**OXFORDSHIRE COUNTY COUNCIL’S RESPONSE TO CONSULTATION
ON THE FOLLOWING DEVELOPMENT PROPOSAL**

Application no: 22/01829/OUT

Proposal: Outline (fixing ‘Access’ only) – redevelopment of Graven Hill D1 Site, including demolition of existing buildings, development of B8 ‘Storage or Distribution’ use comprising up to 104,008 sq. m (GIA), creation of open space and associated highway works, ground works, sustainable drainage systems, services infrastructure and associated works.

Location: Unit D1 Graven Hill, Circular Road, Ambrosden OX26 6HF

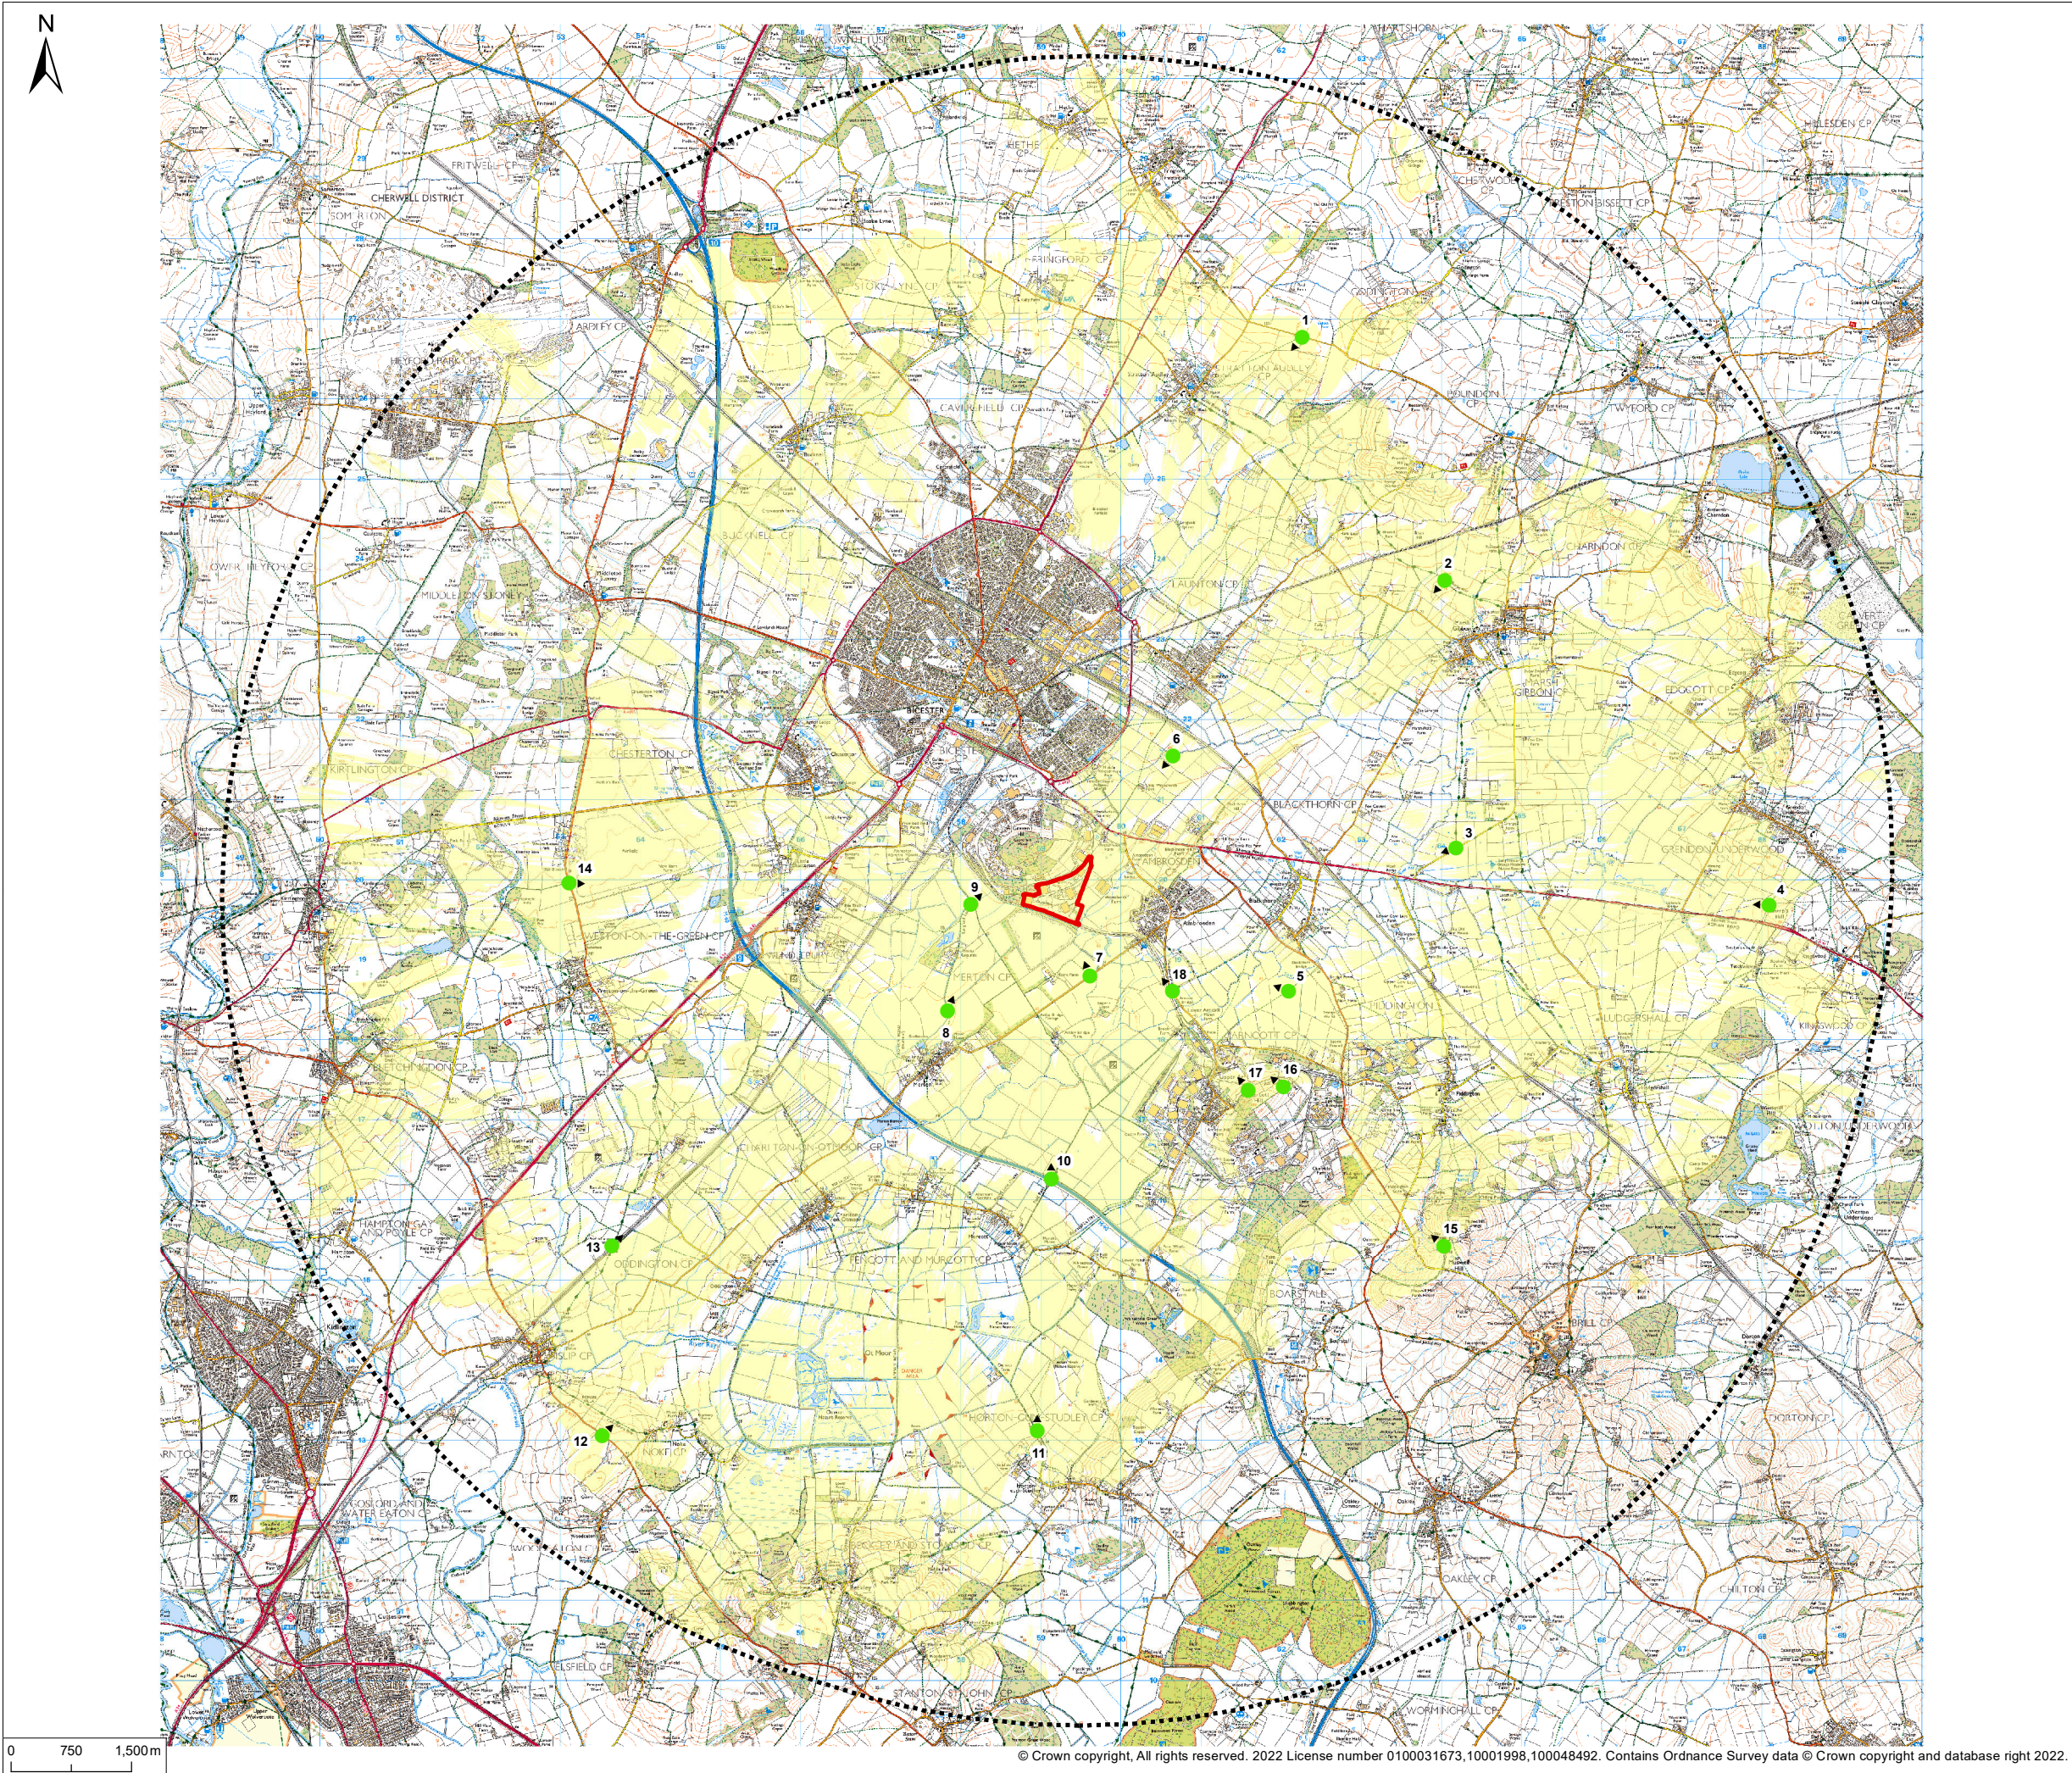
It has come to light, however, that the red line area as shown on the RPS Application Site Boundary drawing and the Atelier Gooch Site Location Plan is incorrect as the vehicular route to the public highway is not indicated along the Employment Access Road (EAR). The applicant has been made aware of this and is due to issue a revised location plan. To confirm, OCC will support the use of the EAR but would object to the use of the route currently indicated which, in fact, is now not feasible as it has been terminated at the new Pioneer roundabout.
